Expert Review

Narrabri Gas Project Environmental Impact Statement and Response to Submissions

I was briefed by EDO NSW acting on behalf of the North West Alliance to provide expert advice relating to the **Narrabri Gas Project Environmental Impact Statement (EIS) and Response to Submissions**. In completing this review I have specifically addressed the following issues in relation to **Groundwater Dependent Ecosystems (GDEs)**:

Figure 3-9 Groundwater bores monitoring shallow groundwater sources

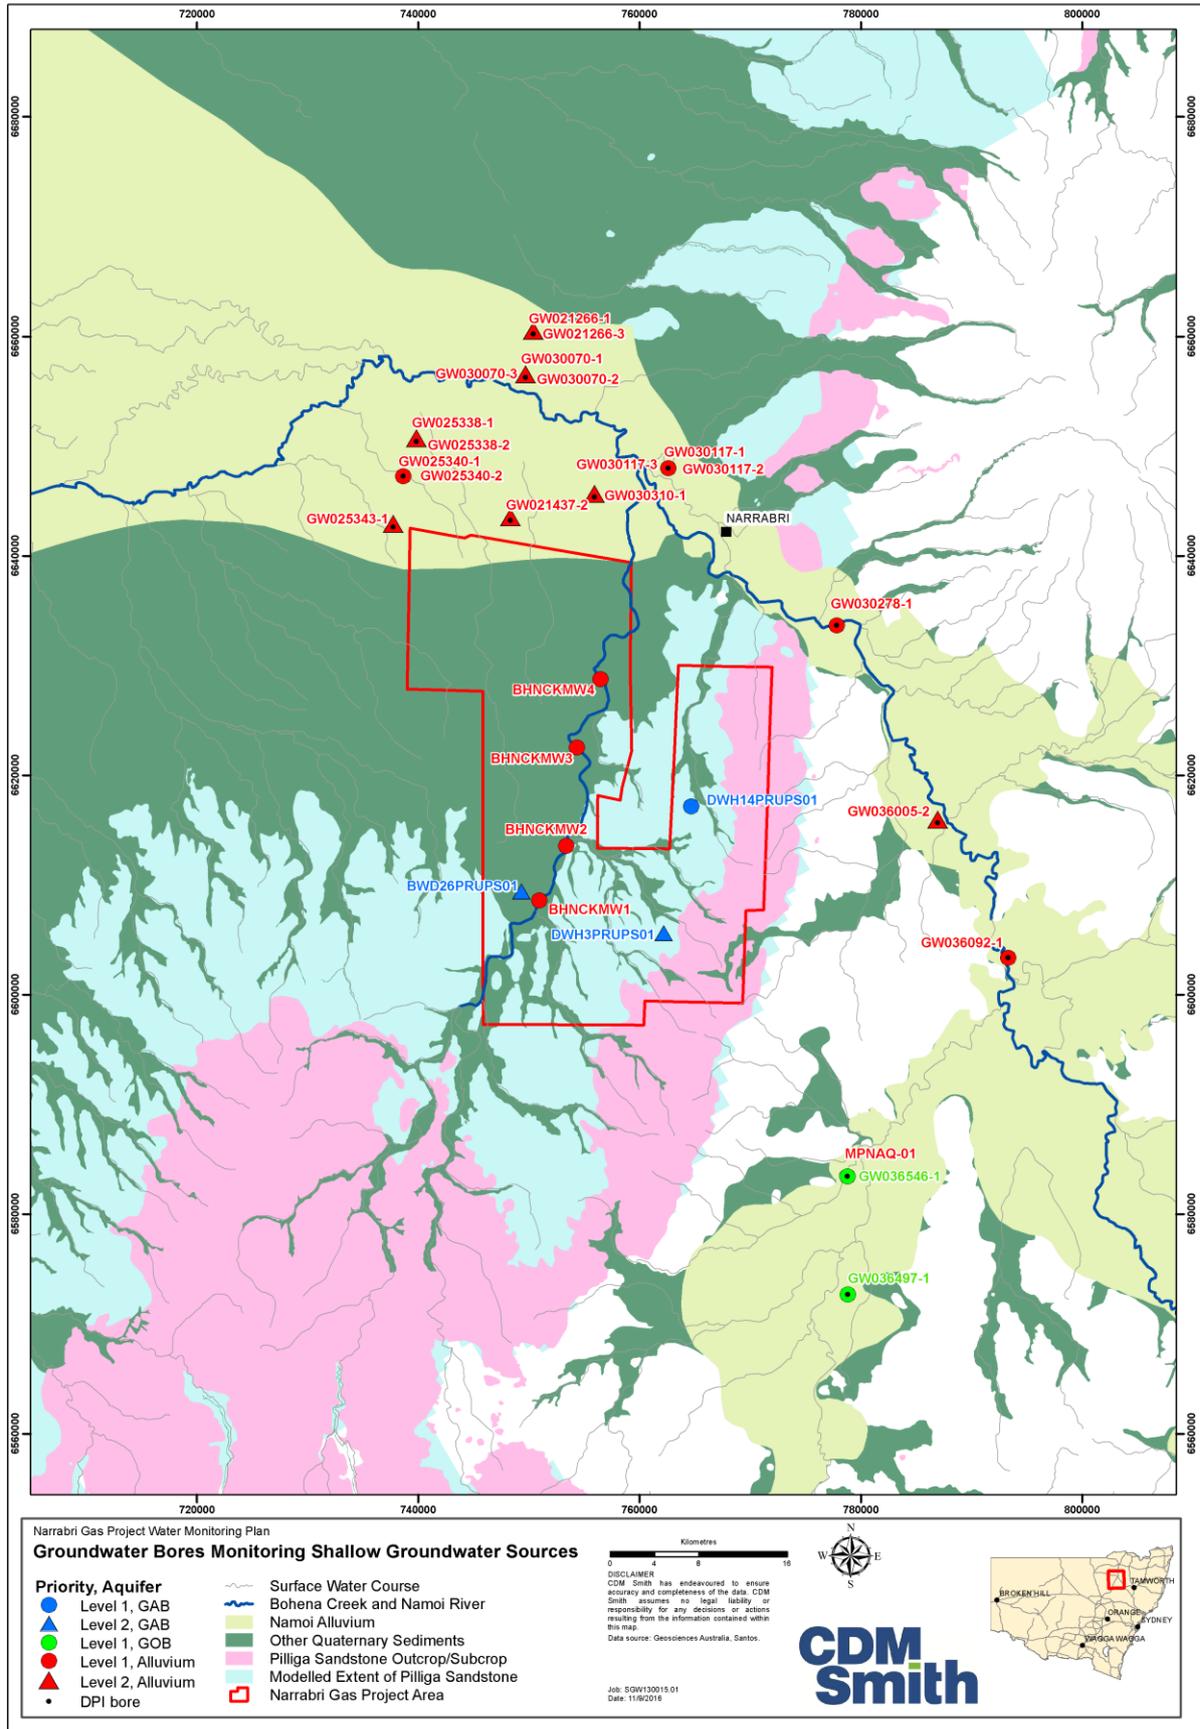
The Proponent has not included GDEs in the monitoring plan because 'there is an insignificant risk of impact due to the large degree of physical separation, both vertically in the sub-surface and horizontally at the surface, and therefore lack of connectivity between the target coal seams and GDEs'. Further, the Proponent states in the EIS that baseline data on GDEs is not needed because they will not be monitored.

The current exclusion of GDEs in the Water Monitoring Plan is unacceptable. Monitoring of GDEs is needed because the proposed development may cause changes to GDEs that may not be detected by changes in water quality and quantity. This is particularly important because the sensitivity of the biota in GDEs to environmental changes is poorly known. A comprehensive monitoring program should regularly observe the potential stressors (here water quality and quantity) AND the response in the target system (e.g. GDE condition). The Response to Submissions repeatedly cites that the monitoring program will be "focussed on early detection of a specific and measurable change... in water quantity or quality within water assets...". Monitoring should also include monitoring condition of the assets (GDEs) to be protected.
